Our ref: HMS ID 11476

Advice on Modification Report – State Significant Development

Proposal: Birriwa Solar Farm (SSD-29508870)- Modification 1

Major Project reference: SSD-29508870

Figure 4-1: Pedestrian coverage of the survey area.

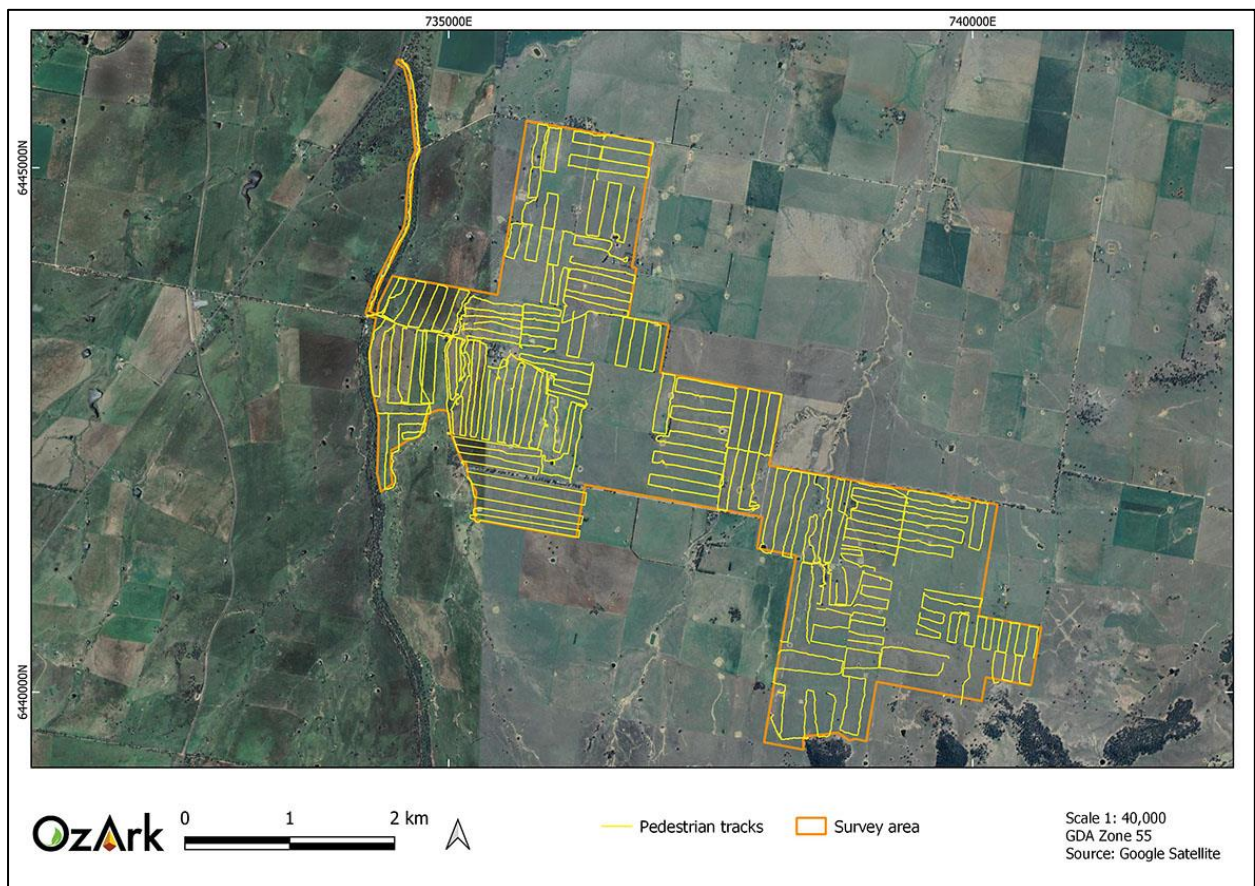
3. Heritage NSW note that the survey tracks shown in Figure 6.2 of the ACHAR do not provide full coverage of the project area. In accordance with Requirement 5 of the *Code of Practice for Archaeological Investigation of Aboriginal Objects in New South Wales* (DECCW 2010), full survey coverage is required unless clear justification is provided. In consideration of this:

- a. Additional survey is required to cover currently unsurveyed areas. Please update the ACHAR to include additional survey tracks, discussion of additional survey areas and any updates to the predictive model and conclusions.
